From: Anita Gardner
Sent: 18 December 2017 10:41
To: Planning.Responses
Subject: FW: FG/151/17/DOC - Discharge of condition 3 surface water drainage Ferring Country Centre, Ferring
Importance: High

From: [REDACTED]
Sent: 15 December 2017 16:43
To: Anita Gardner
Cc: Phil Acton
Subject: FG/151/17/DOC - Discharge of condition 3 surface water drainage Ferring Country Centre, Ferring
Importance: High

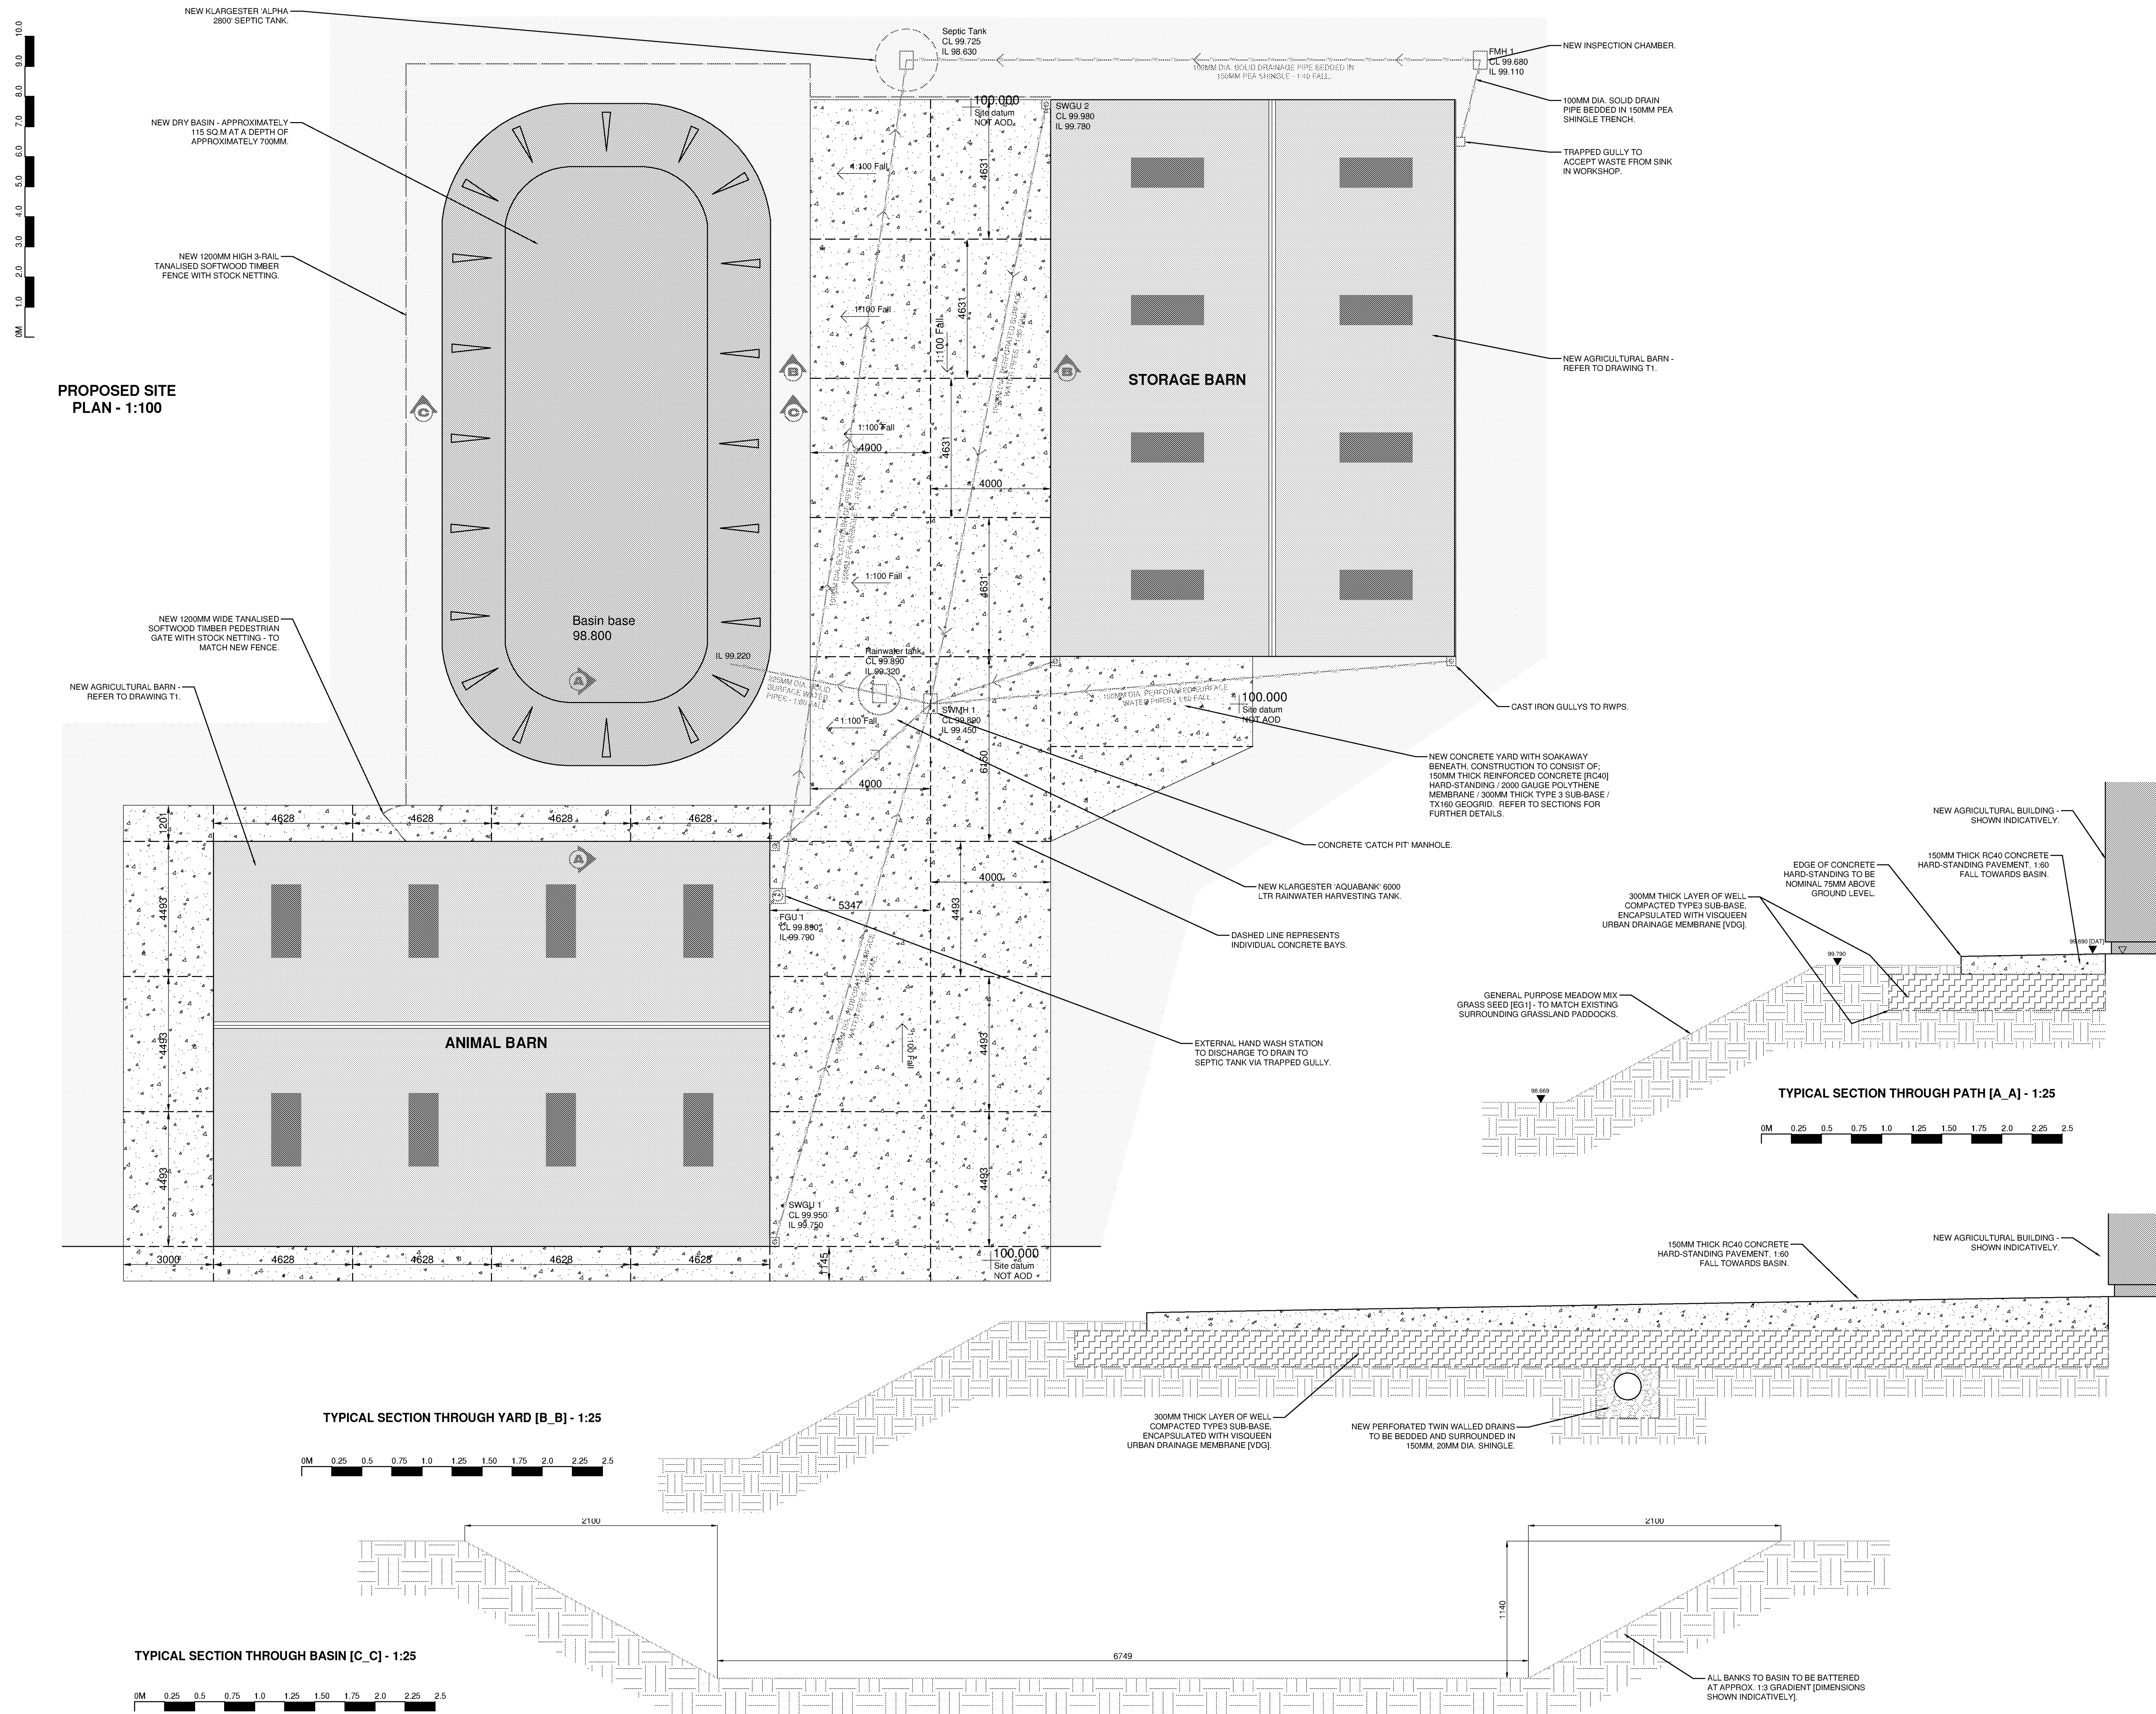
2. The headwall being proposed to the basin will need to be concrete bagwork (ST4 concrete) with the bags pinned together with reinforcing bars or similar. Shown indicatively on drawing PL3.
